Our ref: A63 Castle Street Improvement, Hull
Your ref: TR010016

A63 CASTLE STREET IMPROVEMENT, HULL

On behalf of Highways England, I would like to submit a number of application documents that have been amended following acceptance of the DCO application.

Drawing Title
LAND PLANS REGULATION 5(2)(i) SHEET 3 OF 6

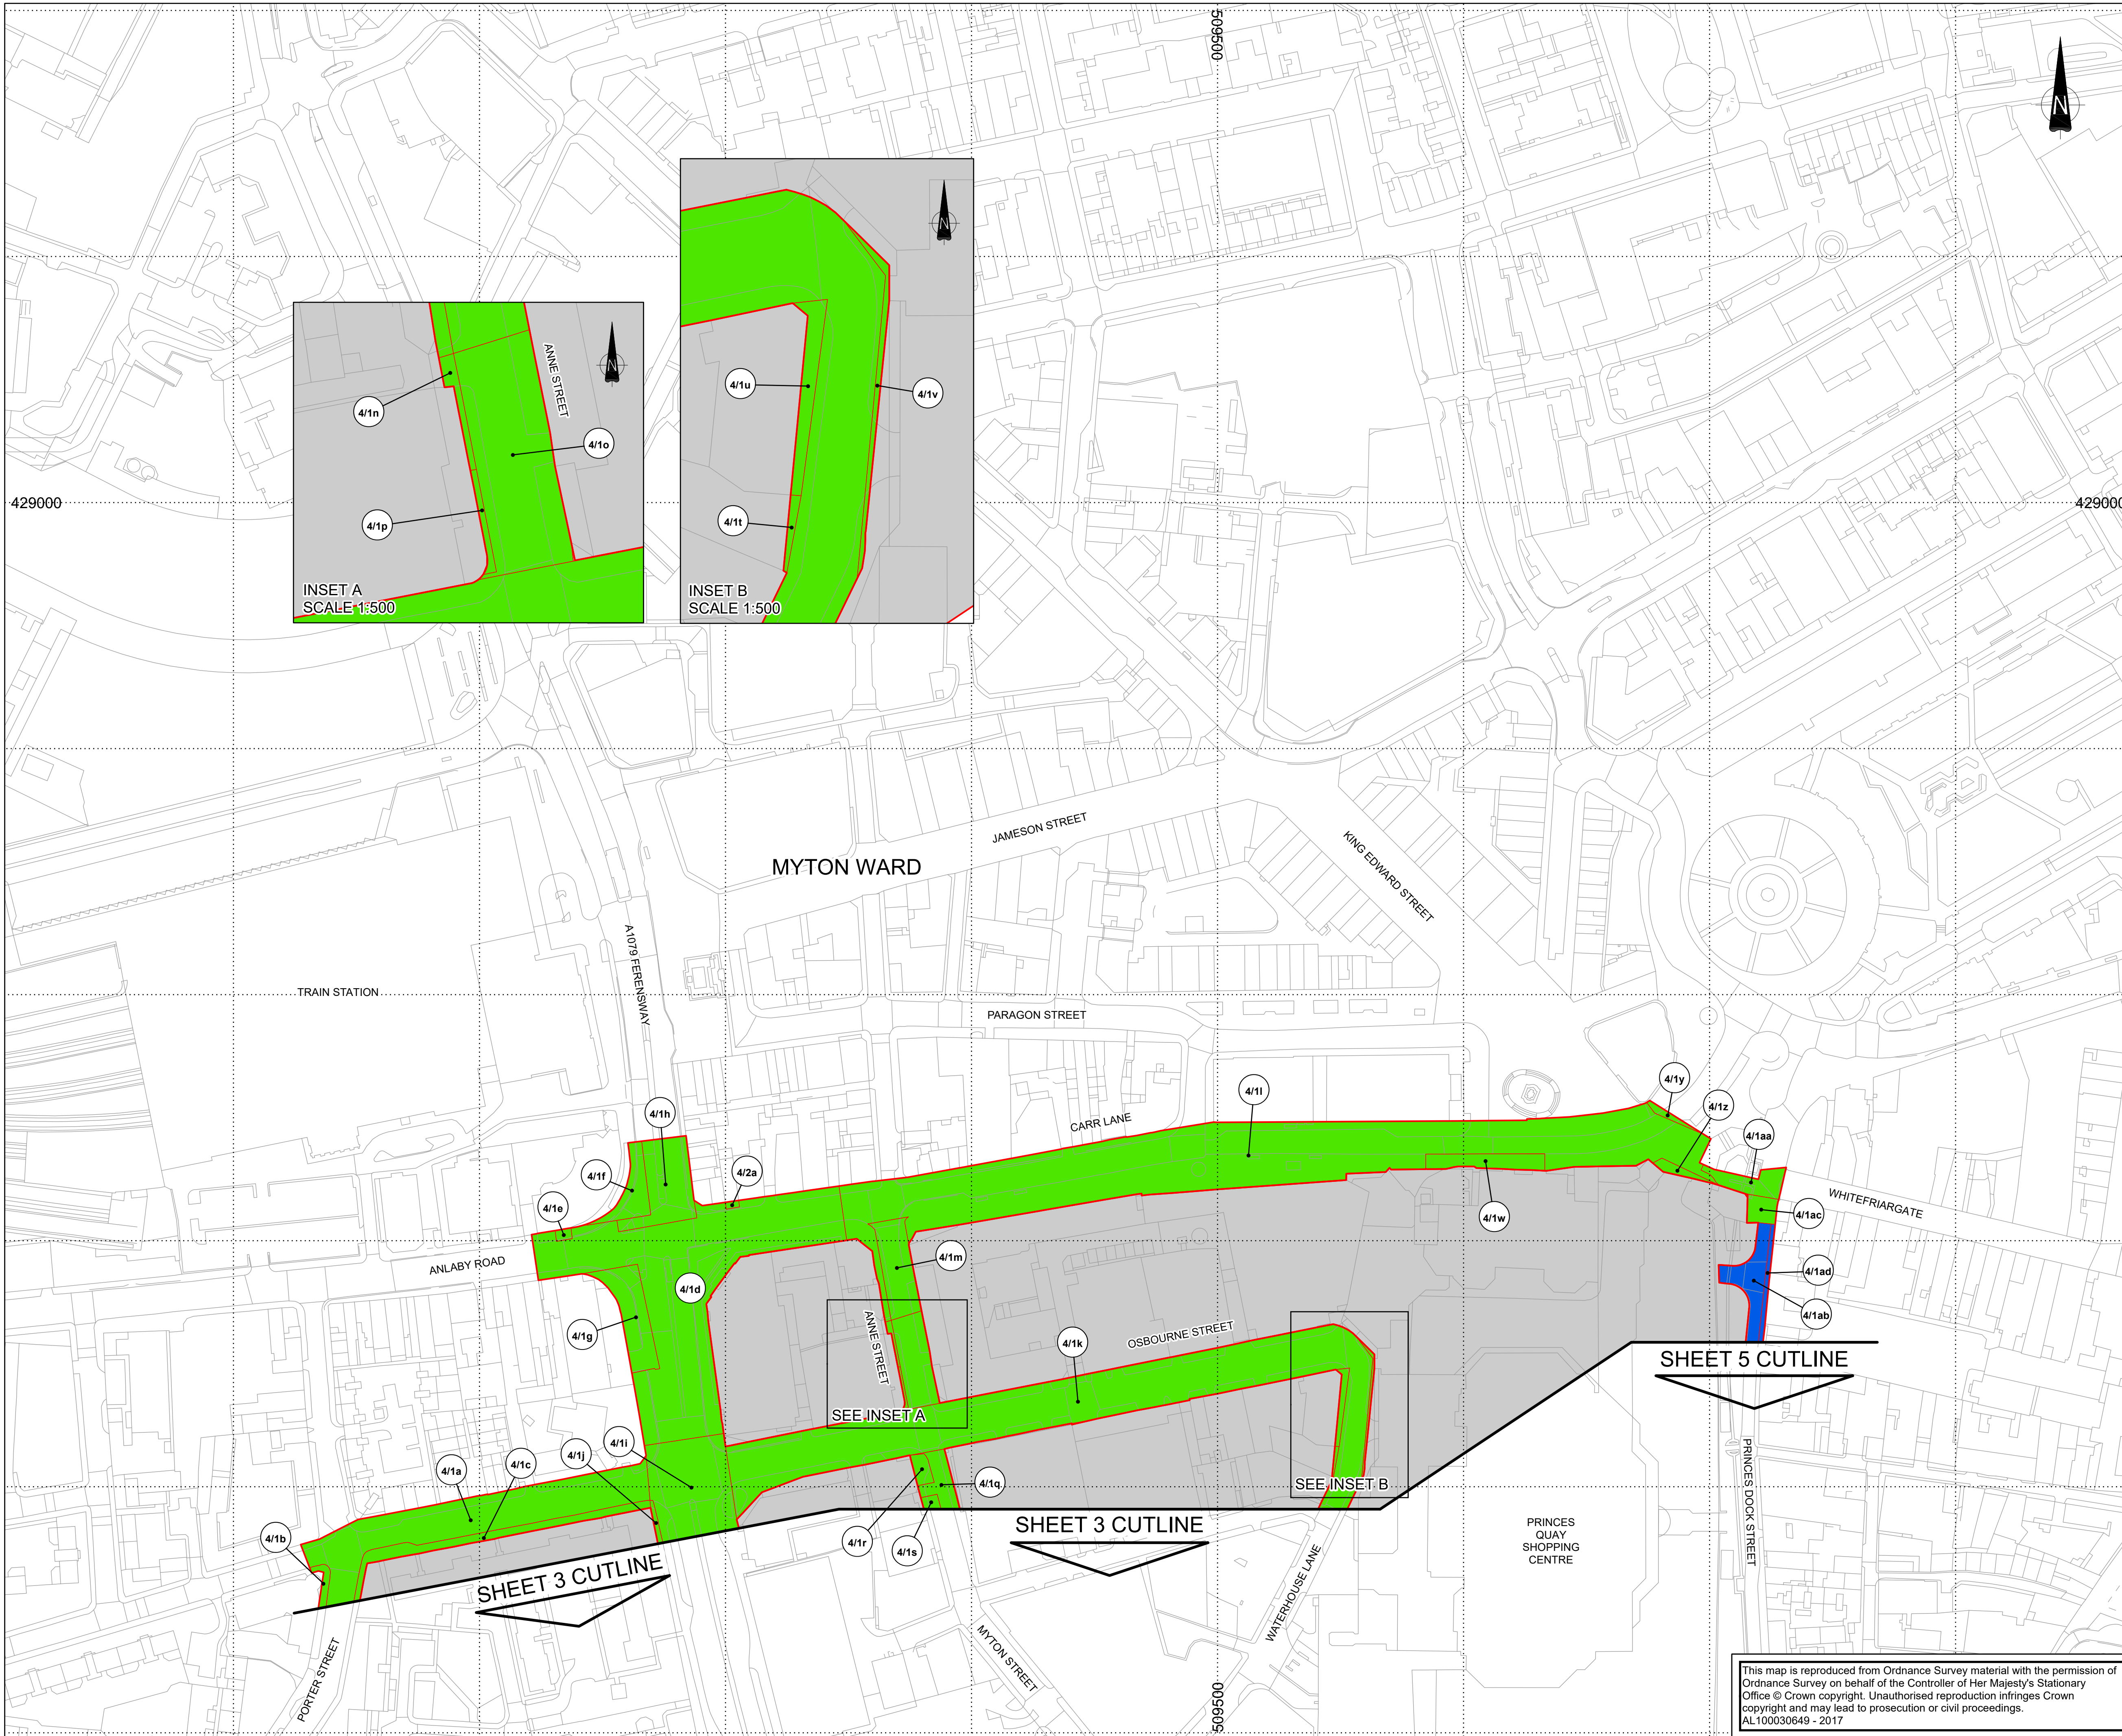
- Amendment to sheet 3 (TR010016/APP/2.3(DA)) to address the S55 comment "*There is an unnumbered plot on sheet 3, adjacent to plot 3/3b*"
- Amendments to sheet 3 (TR010016/APP/2.3(DA)), (TR010016/APP/2.3(DB)) & sheet 4 (TR010016/APP/2.3(E)). Additional plots included to present the new information received in relation to changes to Special Category Land.
